REFUSAL OF PLANNING PERMISSION

APPLICATION NO. 2016/1488

Proposal Erection of front two storey and single storey extensions to dwelling

At 50 Pengeston Road, Penistone, Barnsley, S36 6GW

Proposed Front Elevation

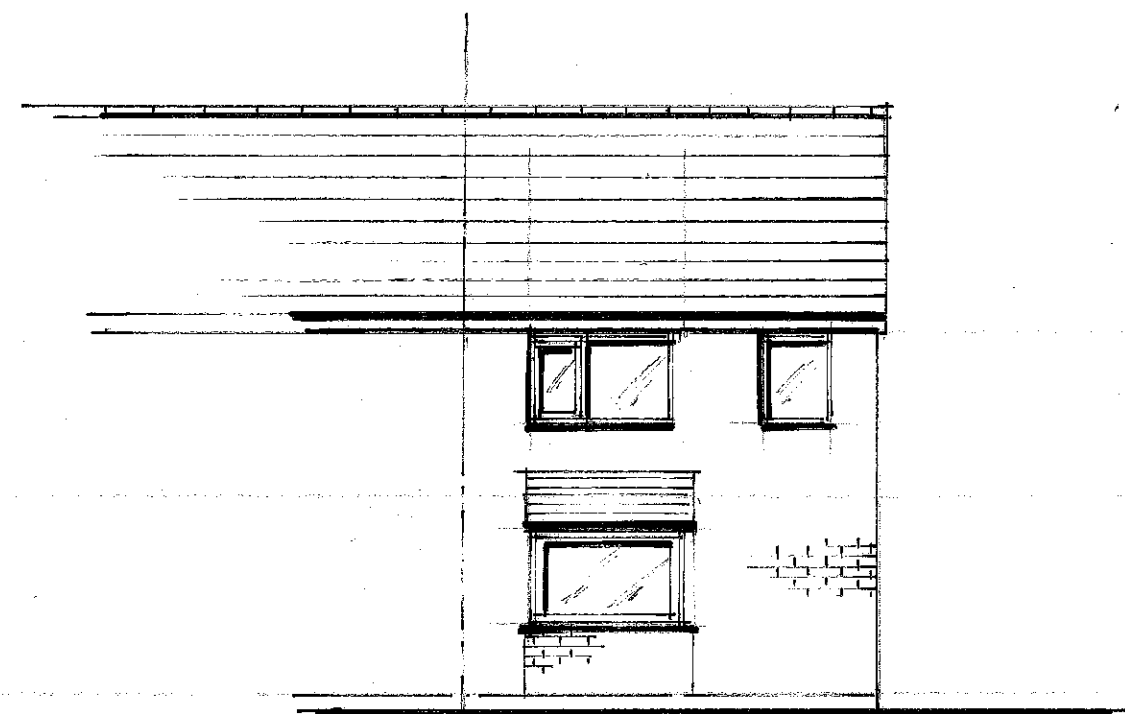
In the opinion of the Local Planning Authority the proposed two storey front extension would be contrary to Core Strategy Policy CSP29 and the Council's Supplementary Planning Document, House Extensions in that its design and scale alters the character and symmetry of the original dwelling, would be architecturally inconsistent with the character of the property, and would as a consequence appear as an unduly intrusive feature in the street scene to the detriment of visual amenity.
